May 30, 2002

**Reference: Ferrous Chloride Odor Control Station
City of Albuquerque EPC Project No. 1000896
Re-submittal**

City of Albuquerque
Southside Reclamation Plant
4201 2nd Street SW
Albuq. NM 87105

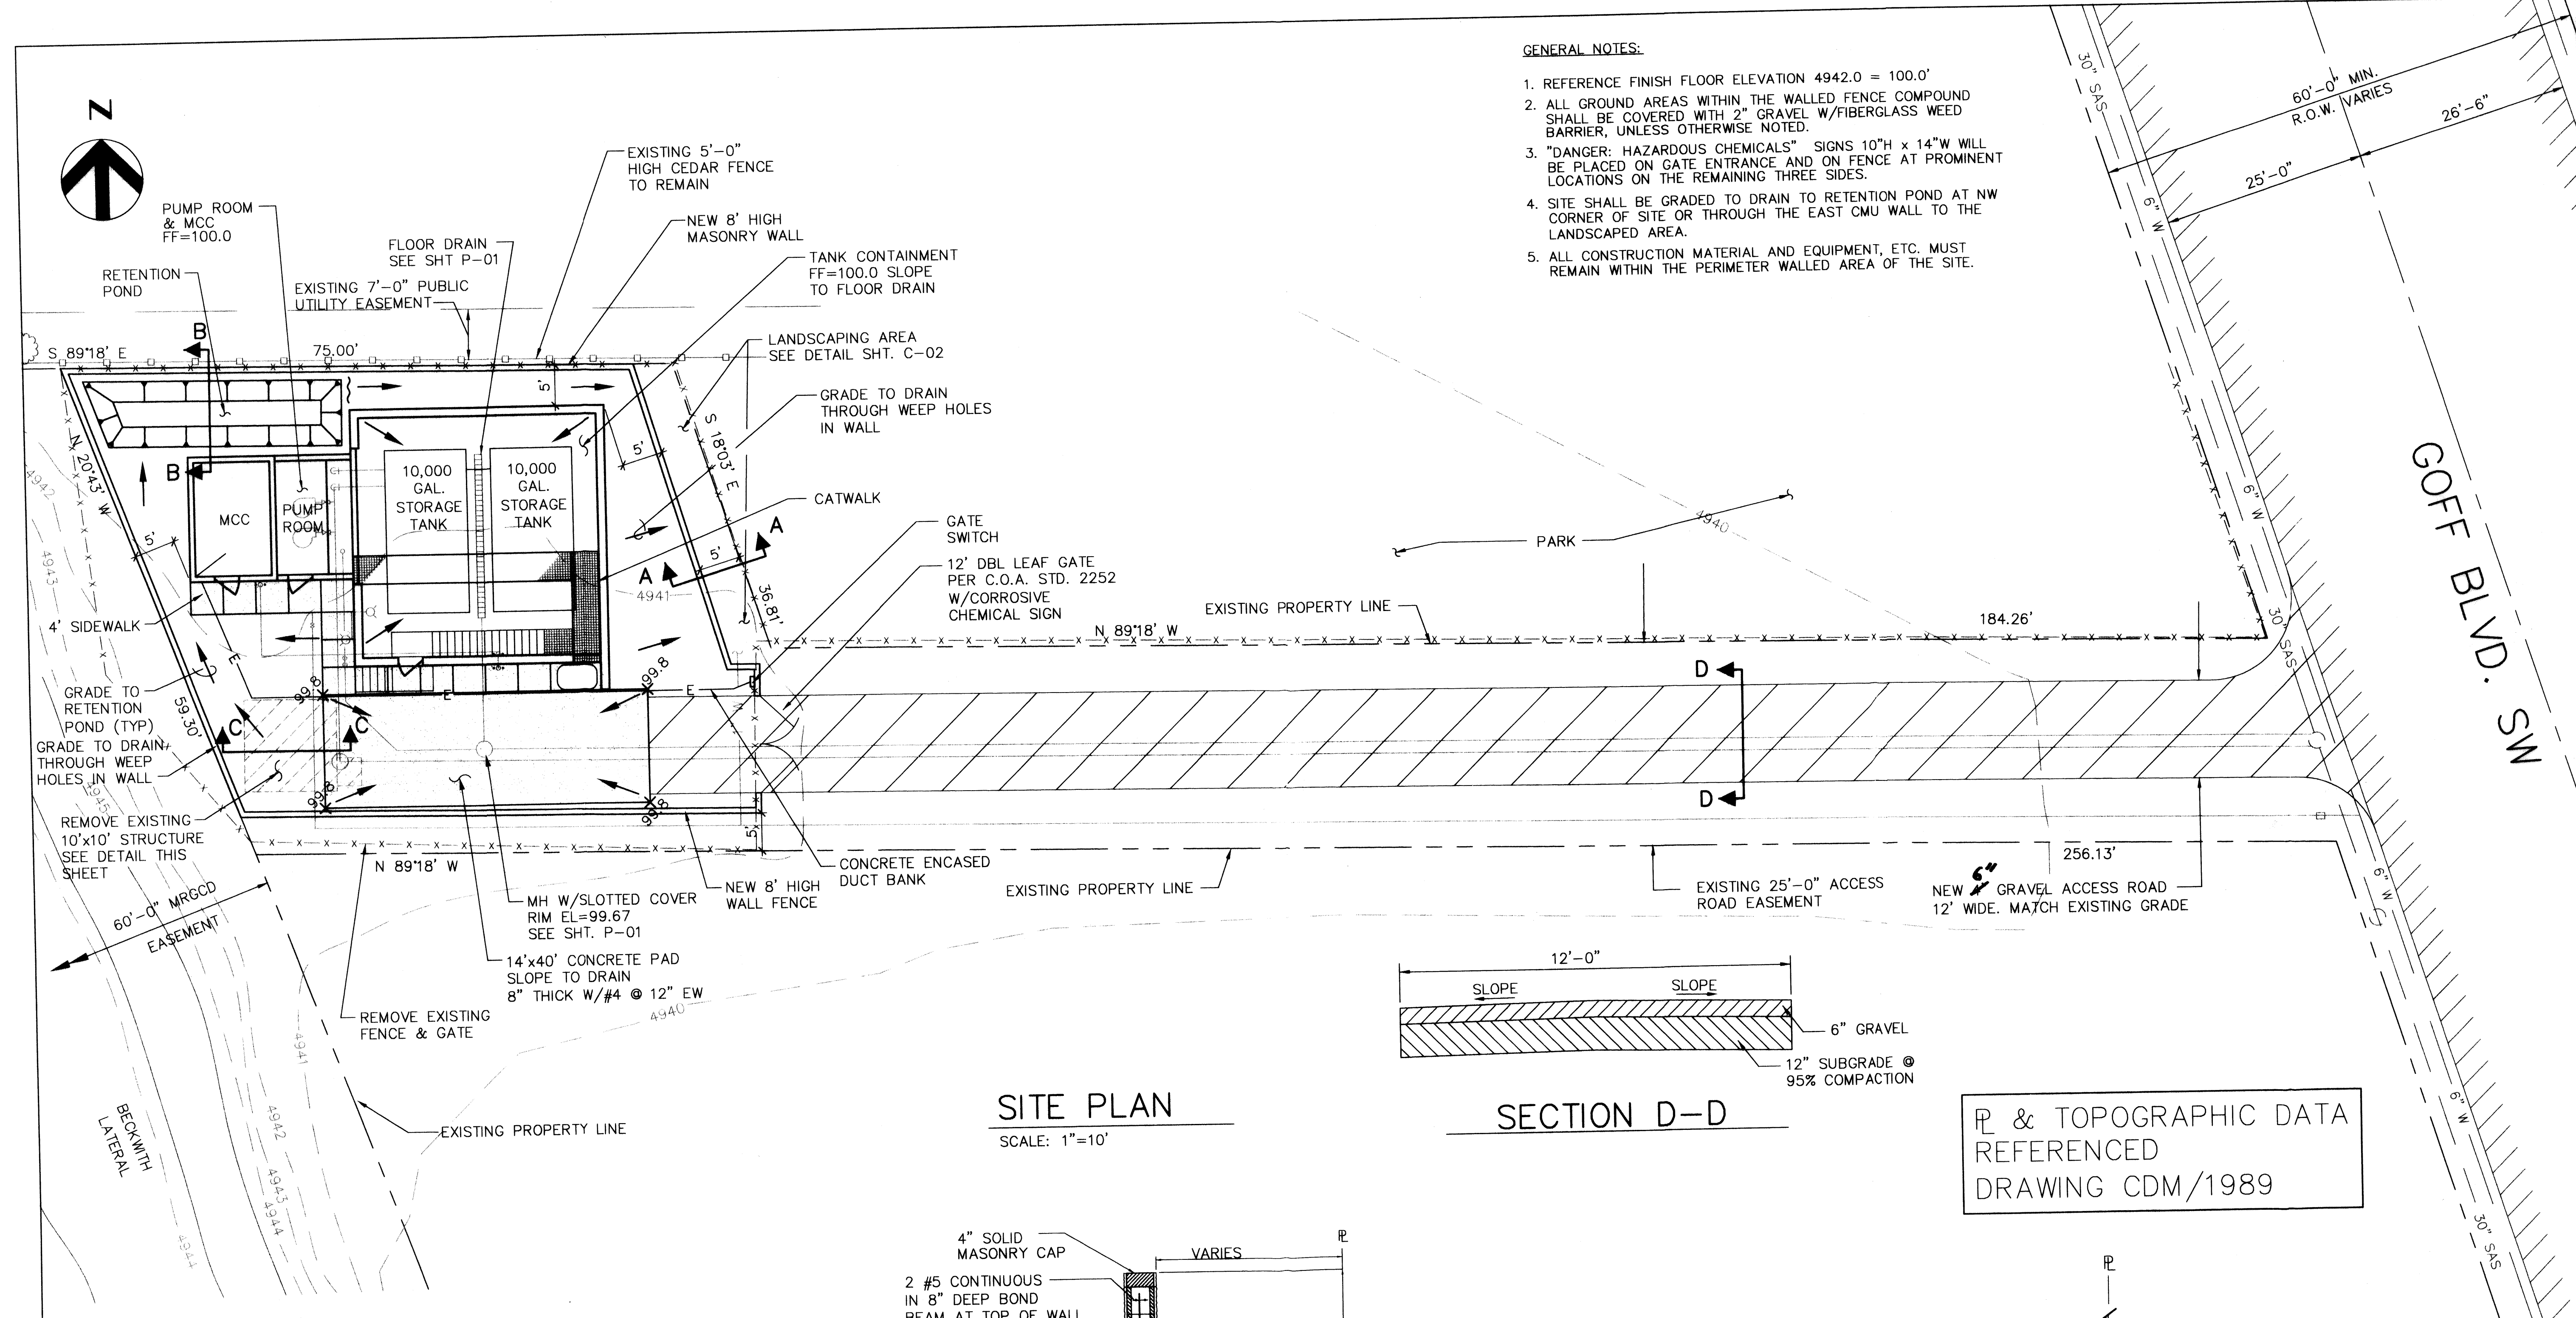
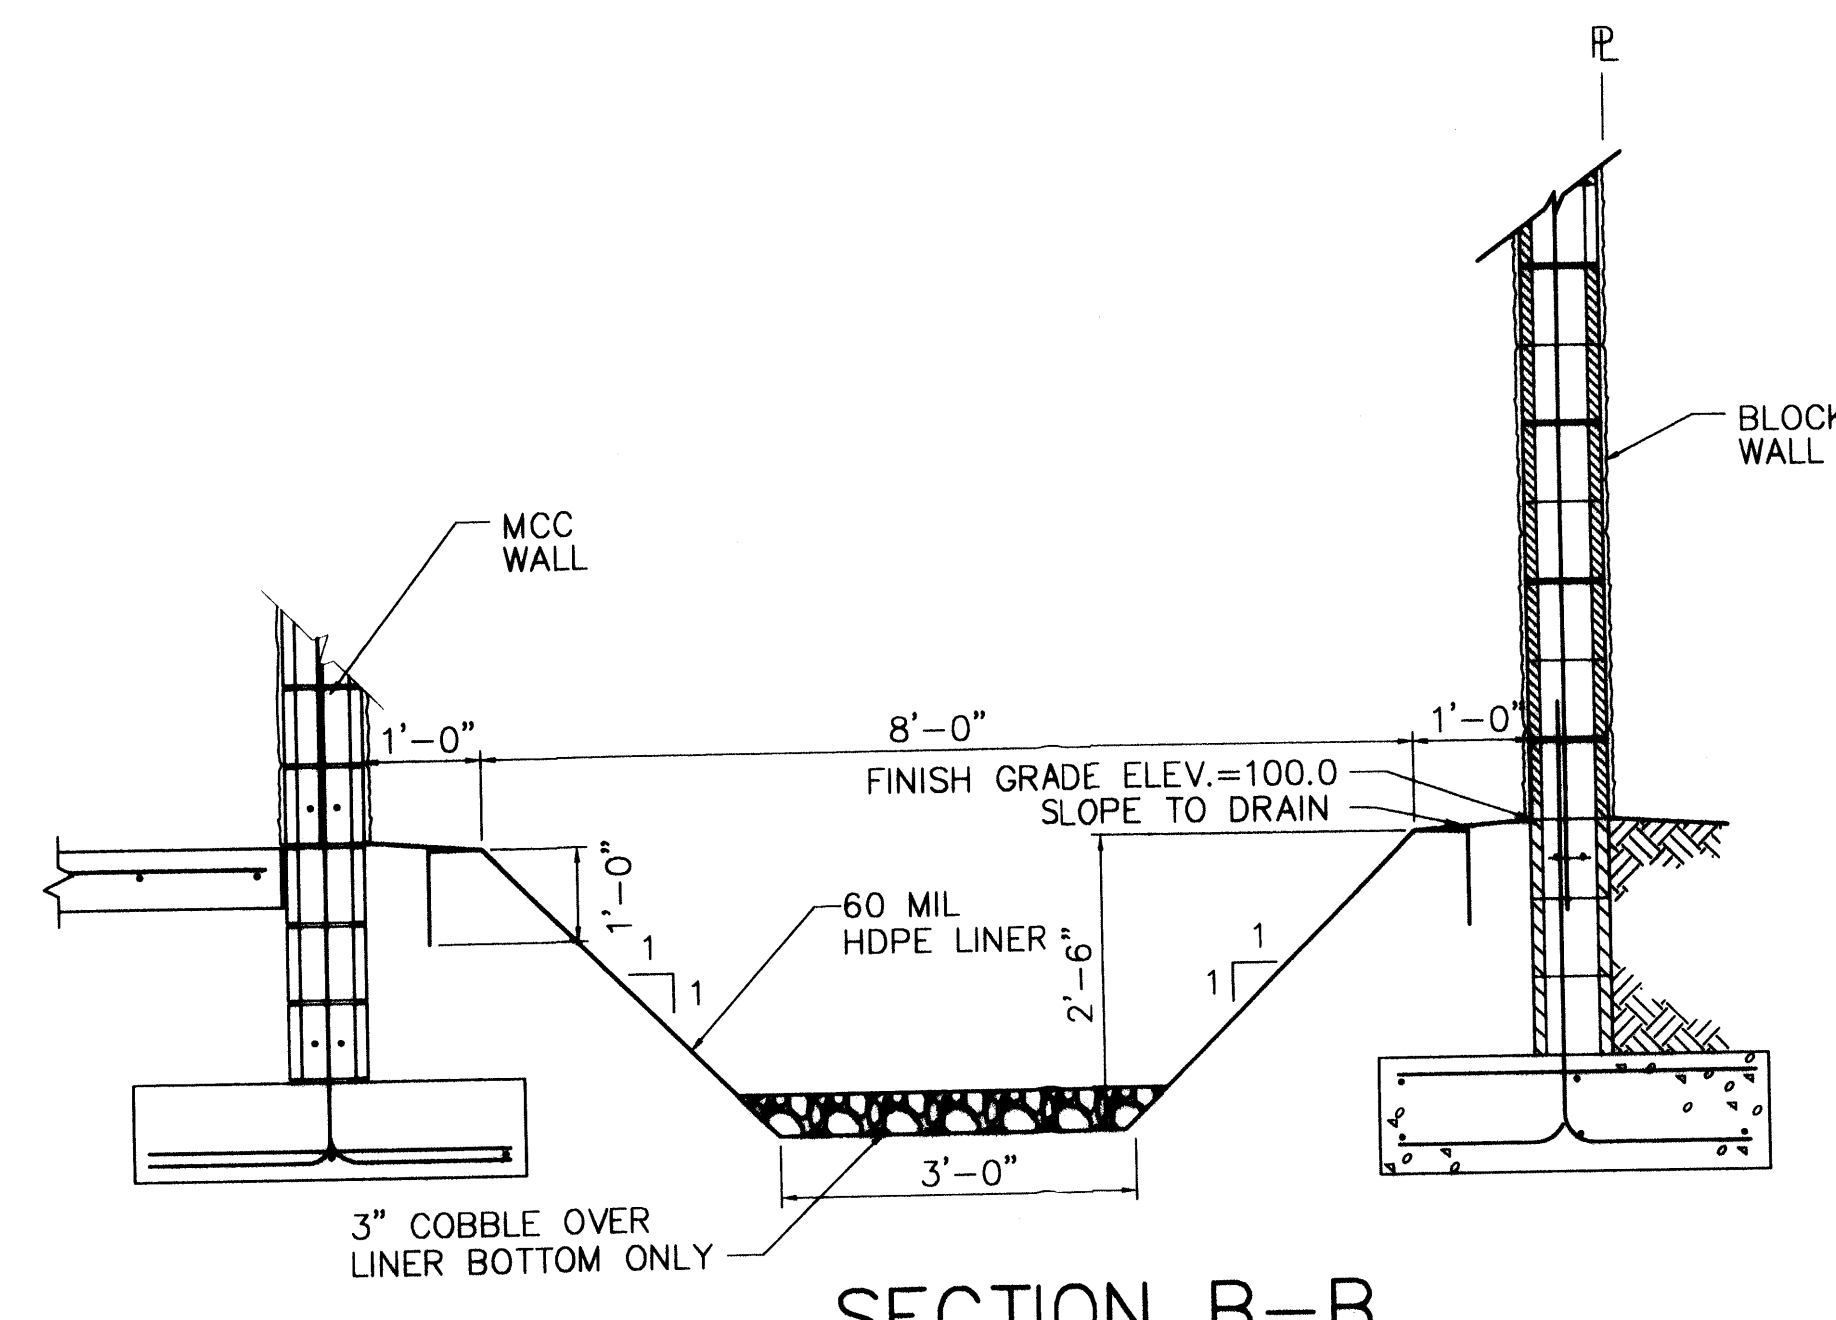
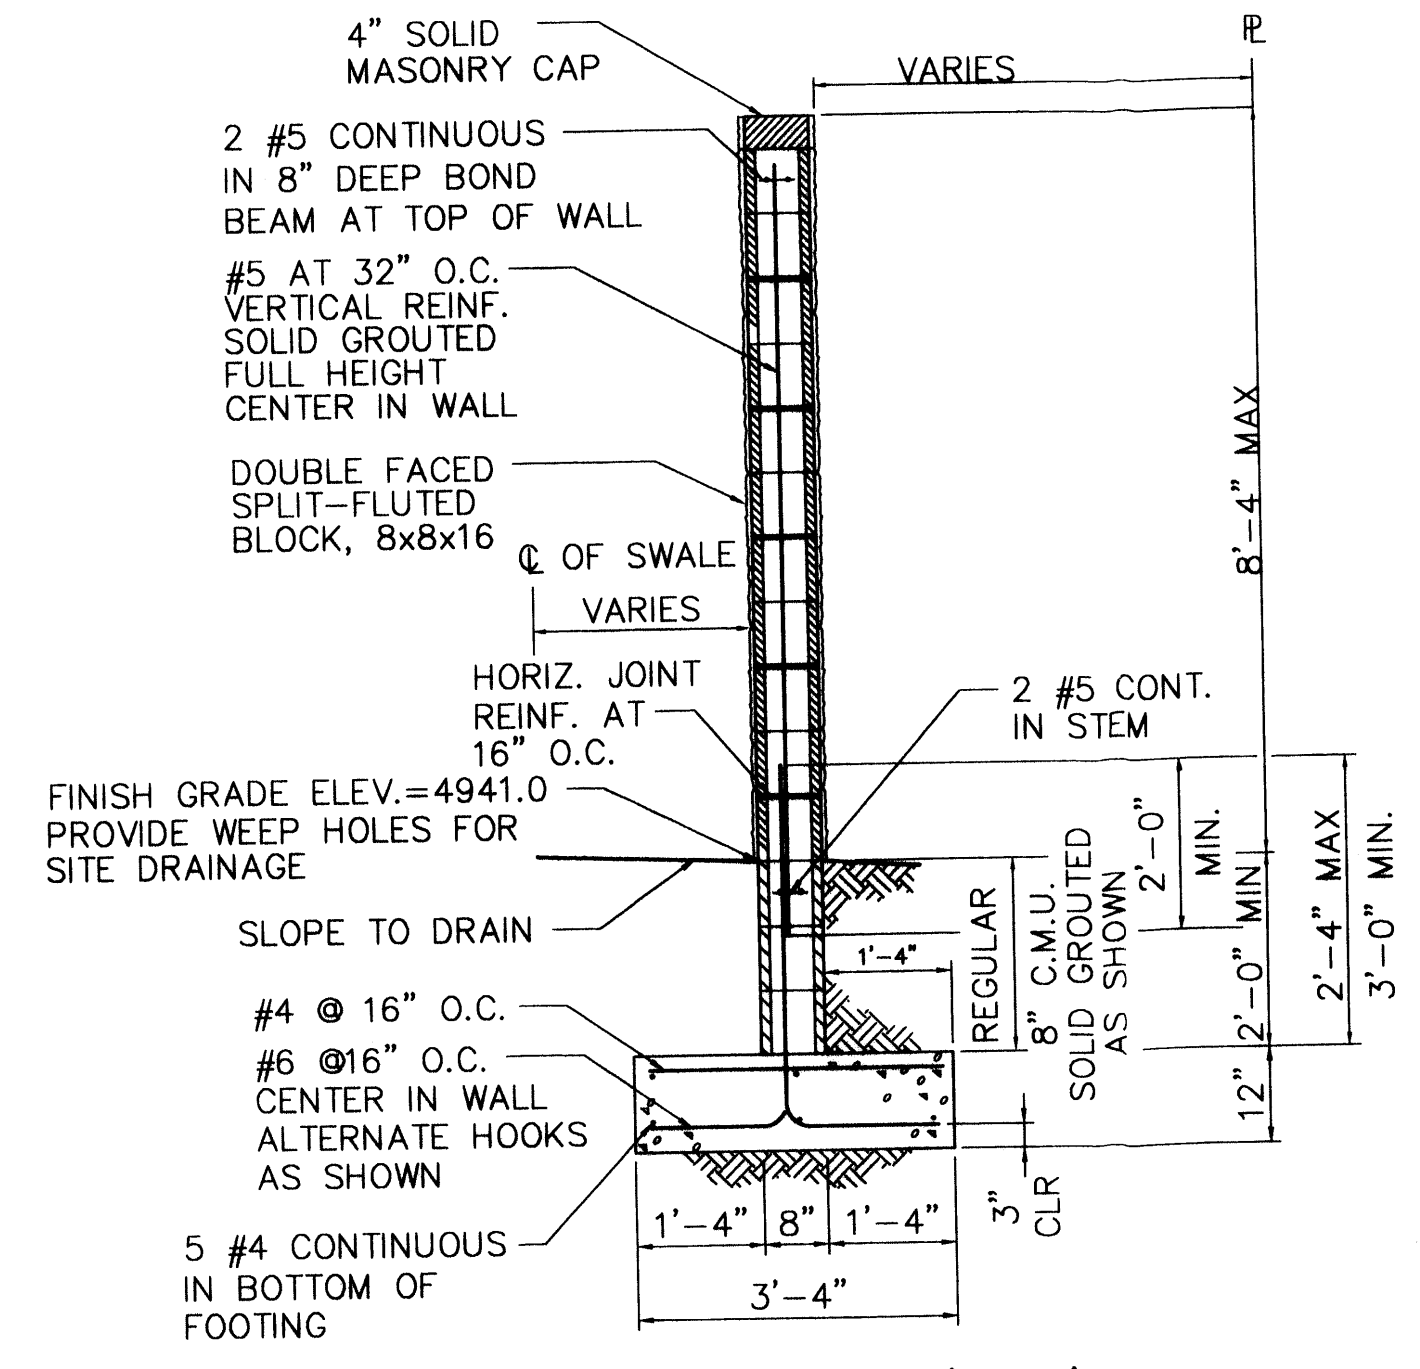
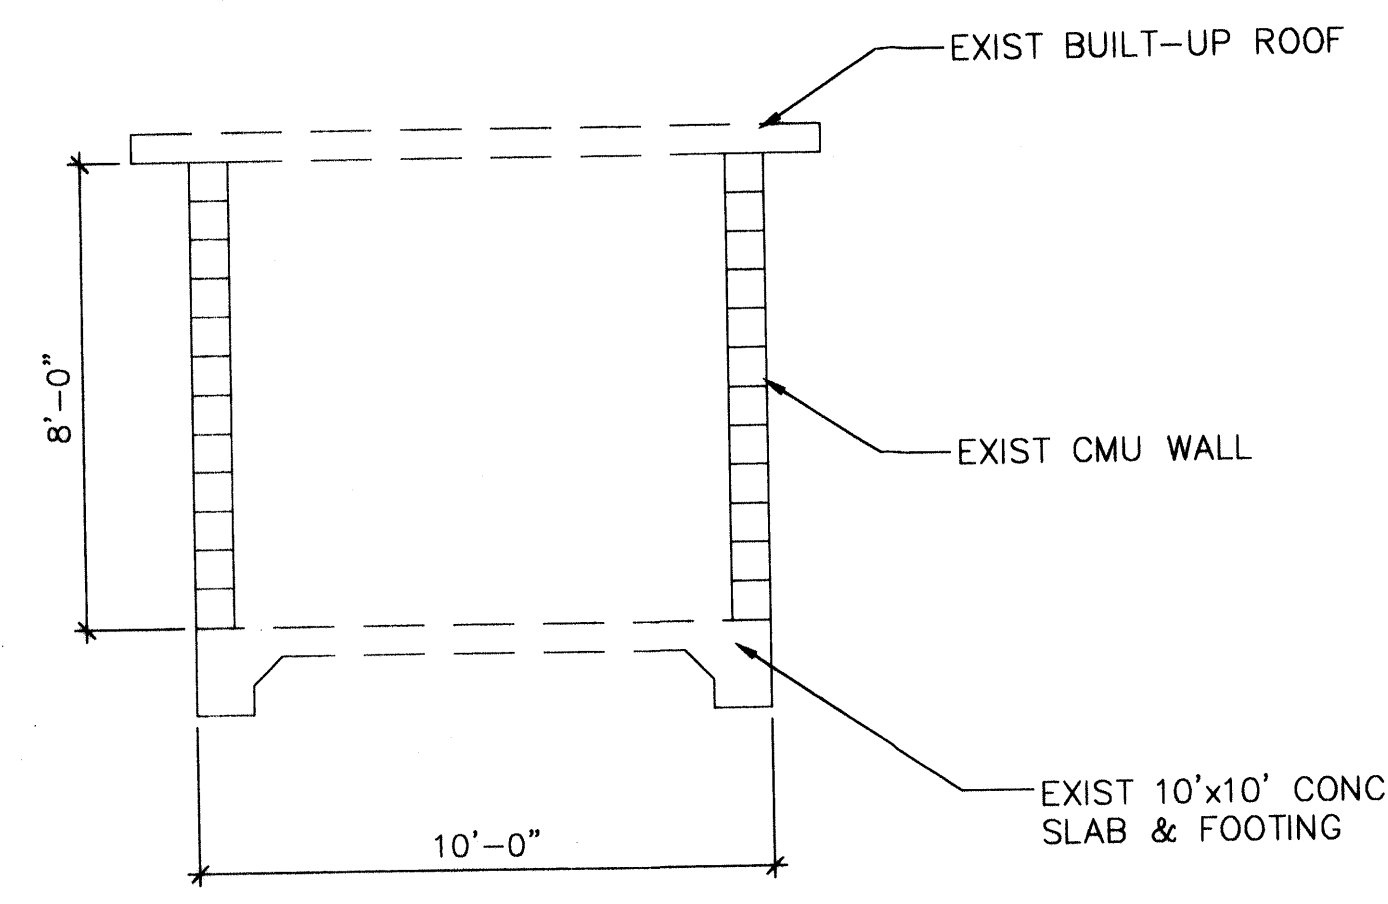
1. Delivery of chemicals will be performed by tractor-trailers. The frequency of these deliveries is expected not to exceed once per month. Other activities at the site are limited to maintenance staff that use pick-up type trucks. This activity is expected not to exceed once per day.
2. Turning radiuses for a tractor-trailer are depicted on the Site Plan.
3. Due to required turning radiuses the tractor-trailers will have to back in and upon leaving go south.

1. This fence will be removed and replaced with a 7' 8" tall masonry wall. This is pursuant to the letter from Mr. Olivas, Conita Real Neighborhood Association and the City's concern for security of the site. Mr.'s Brito and Hill concurred with this change from the EPC Condition No. 6.
2. The gate will be constructed of wrought iron.

- E. Perimeter Wall Alignment – The wall on the west and north sides of the property has been pulled back 2 feet inside the City's property.
- F. Goff R-O-W – We have revised the drawings to reflect current conditions.
- G. Gate – The entrance gate has been changed to a wrought iron type.
- H. Coordination with the Parks Department - A note has been added requiring the City Water Department representatives to coordinate with the City's Parks Department when construction starts.

- 4. Landscape Buffer:
 - a. MRGCD is opposed to this having landscaping along their ditch ROW. See attached letter from MRGCD.
 - b. The properties along the north boundary have wood cedar walls. See attached pictures. There is a 2 foot strip between the proposed masonry wall and the existing wooden walls. Planting landscaping in this 2 foot buffer strip would be of no benefit nor would it be assessable.

- 5. Concur. There is only one motor, which is mounted outside. This motor operates a compressor, which will be equipped with a silencer.
- 6. This would leave approximately 20 feet of the tractor-trailer delivery truck being outside the gate. This is an unsafe condition being the site is adjacent to the Park.
